# HAVEN VALLEY

**PRELIMINARY GRADING PLAN**

# Grading & Erosion Control Plan\_v4.pdf Markup Summary 5-9-2022

PRELIMINARY GRADING PLAN

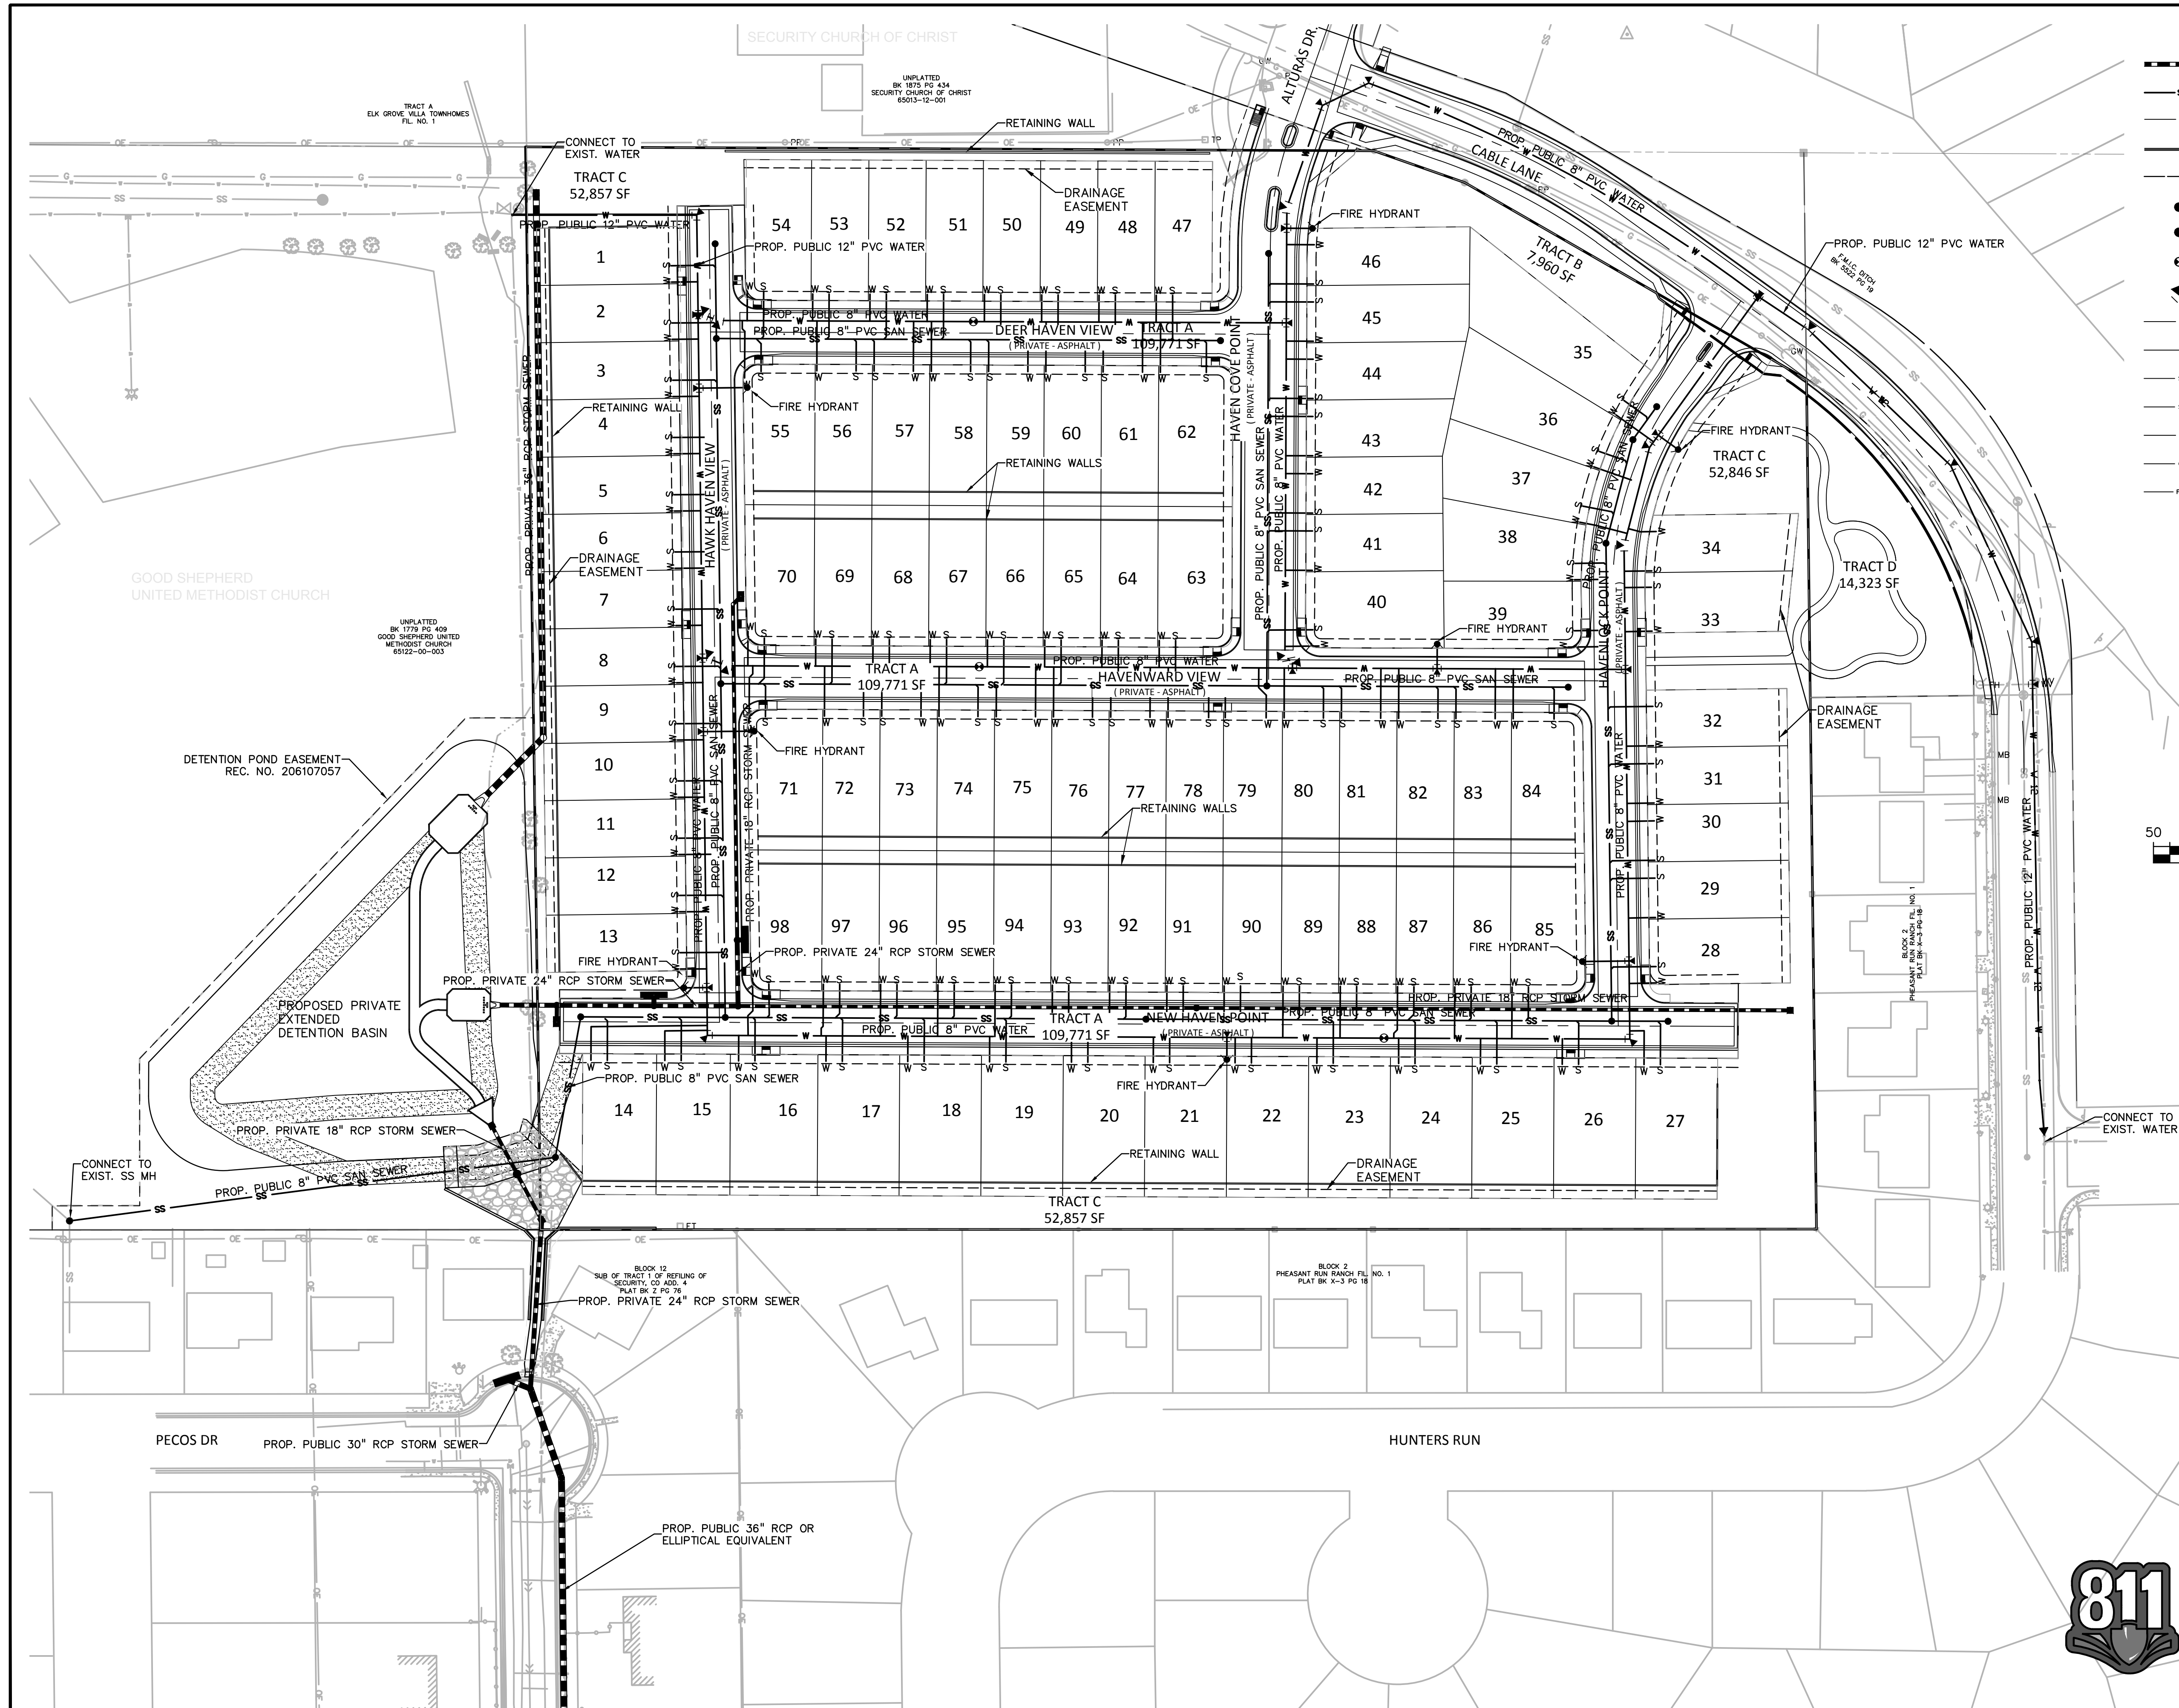
Please remove the distance shown. The smallest roadway per the PUD and TIS is an urban local low volume roadway which will have a minimum 24' paved width which would not be obtained with these smaller distances. Please also show the paved width dimension.

please revise the distance such that it meets the urban local roadway standards (17.5' to back of curb and 30' min. paved width)

Recommend showing the distance on the cross sections to the back of curb to be consistent with the sections on the PUD plan and for clarity.

per previous comment, please provide the paved width distance.

please provide the paved width distance
